UDRP Report

110, 116 York Street

RE: Response to UDRP Recommendations – April 4, 2025
110, 116 York Street

On behalf of Claridge Homes ("Claridge"), please find enclosed a response to Urban Design Review Panel Recommendations received following the Urban Design Review Panel hearing on April 4, 2025 at 9:00 am, in relation to the Official Plan Amendment (OPA), Zoning By-law Amendment (ZBLA) and Site Plan Control (SPC) applications for 110, 116 York Street.

WEST ELEVATION
1:150

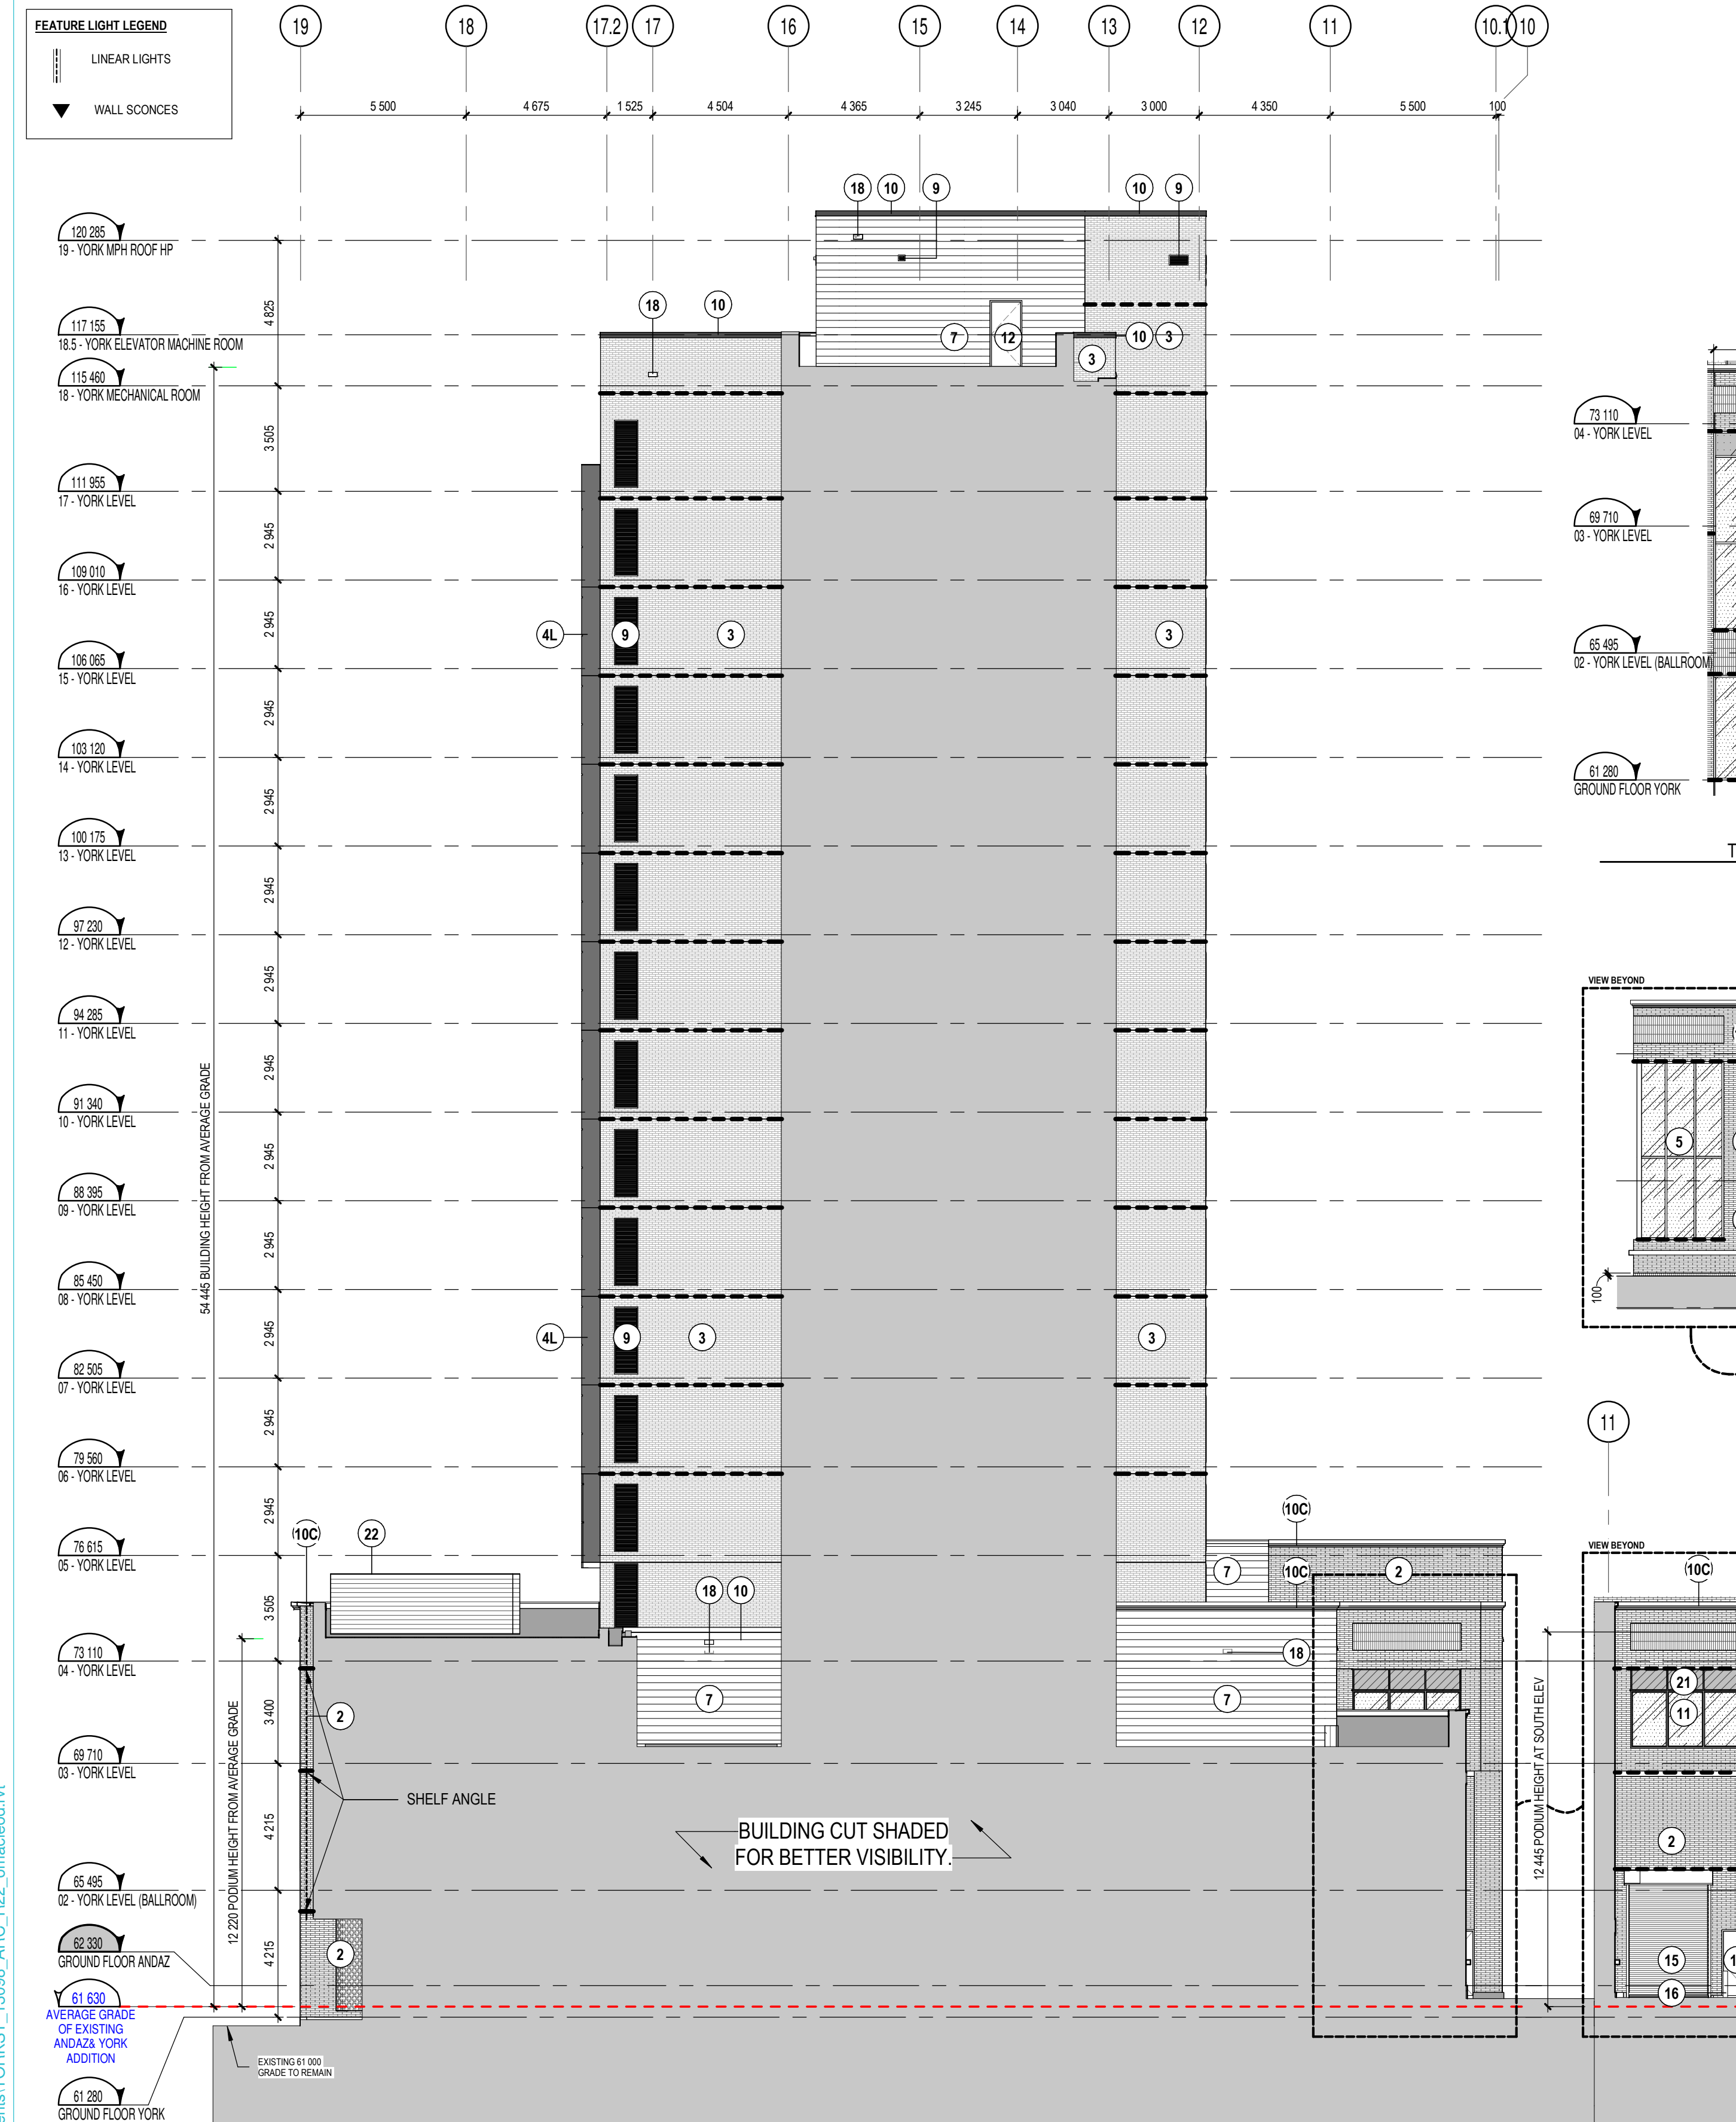
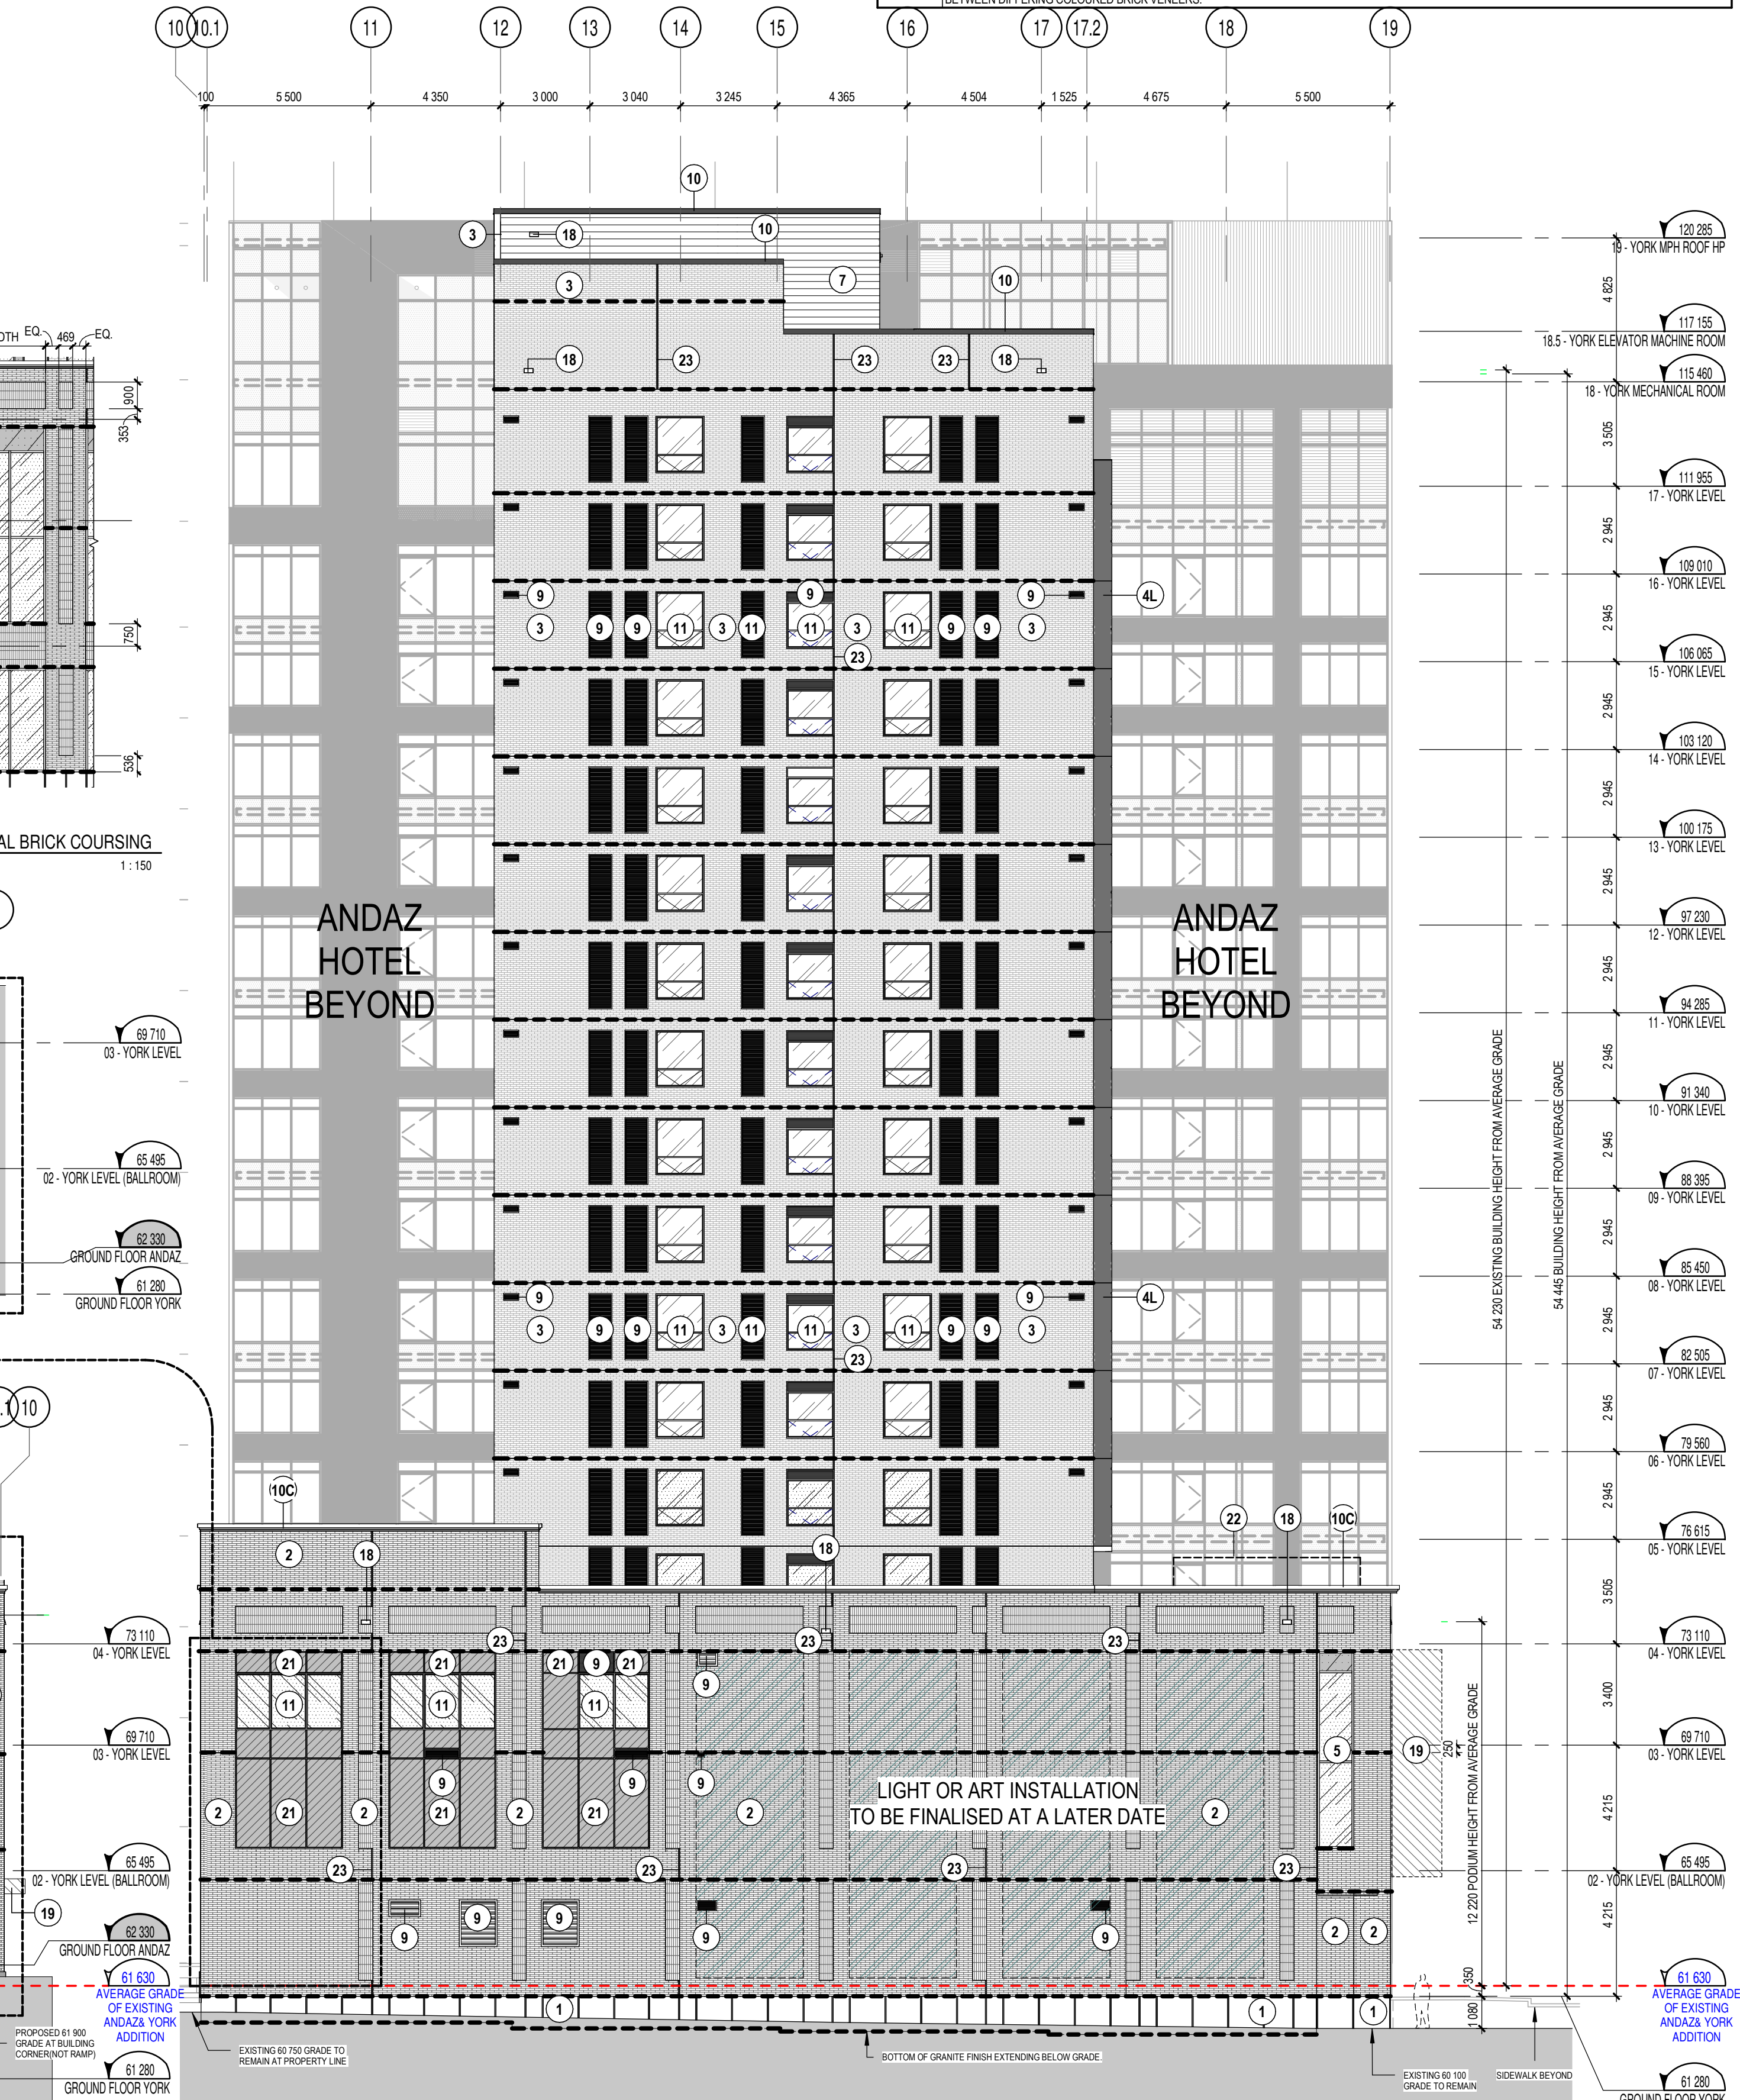
- / The tower materiality should be reconsidered to better integrate with the Andaz and visually recede into the sky view. The current dark material treatment is not appropriate in this context as it overwhelms the base.

13. The Panel recommends refining the tower to improve its relationship with neighboring buildings in terms of both massing and materiality. In particular, the tower should more directly respond to the adjacent building to the east through appropriate step-backs and formal gestures.

Response: This addition aspires to marry the existing Andaz's modular glass and aluminum look to the heritage fabric of the area. The new tower's dark brick scheme with light band is a contrast to the Andaz's light colour scheme with dark band. This contrasting colour scheme helps differentiate both building elements, while maintaining a visual relationship between old and new.

Response: Please see the previous response. Primarily, the proposed building addition responds to the existing hotel building, while aiming to bridge the Andaz's modern massing to the heritage fabric, such as the podium of the building at 126 York Street to the east, and attempting a relationship to the finishes of the neighbouring building to the south. The tower façade has been revised in response to UDRP comments. The façade within the aluminum band and the accent aluminum band are extruded from the tower façade to add greater variety to the north and most public façade of the building.
